February 15, 2021
ES-6947.04

**Subject: Second Response to Comments
Proposed Marbella Residence
7311 West Mercer Way
Mercer Island, Washington**

Reference: Earth Solutions NW, LLC
Geotechnical Engineering Study
Project No. ES-6947.01, dated November 14, 2019

City of Mercer Island, Washington
Geotechnical Peer Review Comment, dated February 2, 2021

A2 STEPPED FOOTING AT SLOPED LOT
 SCALE: NTS

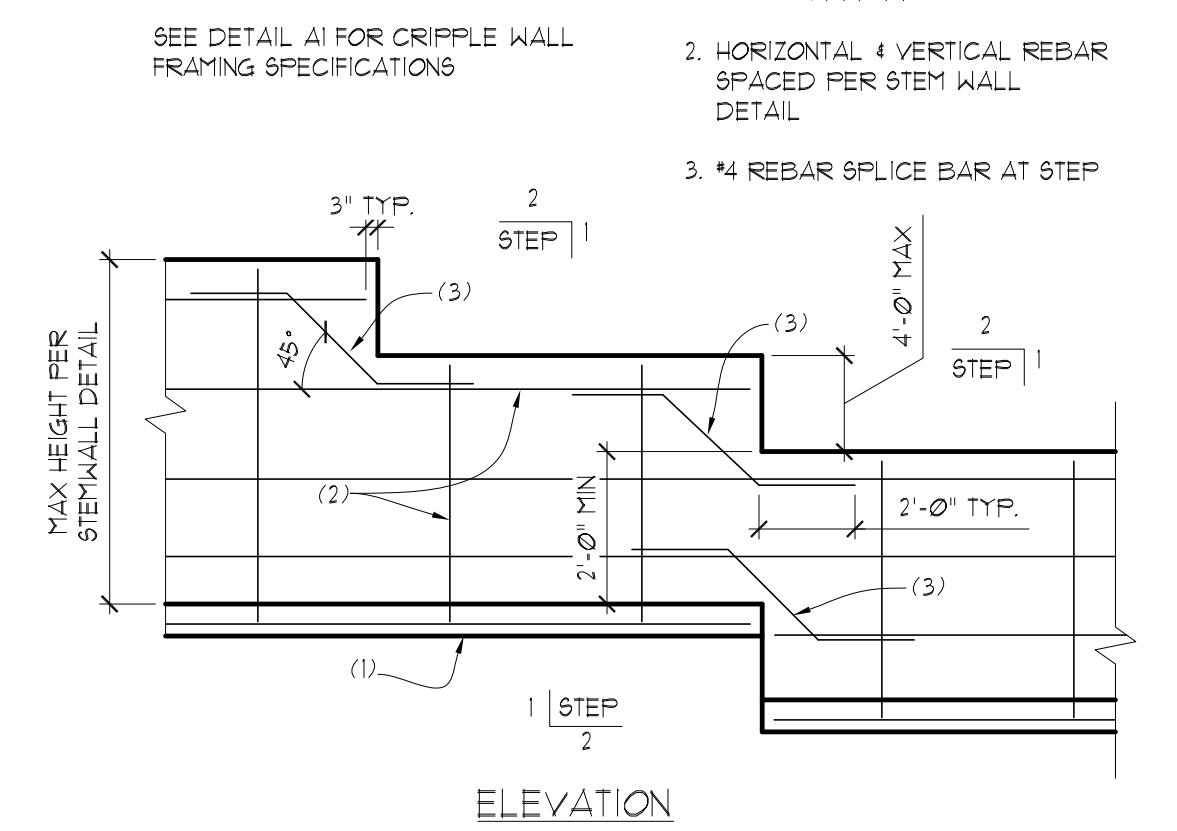
City Comment – Geotechnical engineer to provide recommendations for footings located on or adjacent to steep slopes. Recommendations to include minimum embedment of footings with detail showing footing and slope for clarification and allowable soil bearing pressure given the presence of steep slope. Design recommendations should be included in a letter report format as an addendum to the original geotechnical report.

ESNW Response – In our opinion, foundations near sloping areas should maintain a 10-foot setback from the slope face. This can be achieved by either constructing foundations 10 feet from the top of slope or advancing the foundation sufficiently to maintain a 10-foot horizontal setback between the foundation and slope face. Please see the attached Plate 1 (Foundations Adjacent to Slopes) for a depiction of these recommendations. Provided that competent native soils are encountered at subgrade elevations, the recommended allowable soil bearing capacity of 2,500 psf is considered valid for long-term design of foundation elements. Based on our test pit exploration, we anticipate glacial till to be prevalent throughout the area; as such, we do not anticipate adverse impacts to the slope during foundation preparation activities. ESNW should be retained at the time of construction and foundation preparation to observe field conditions and provide additional recommendations, if necessary.
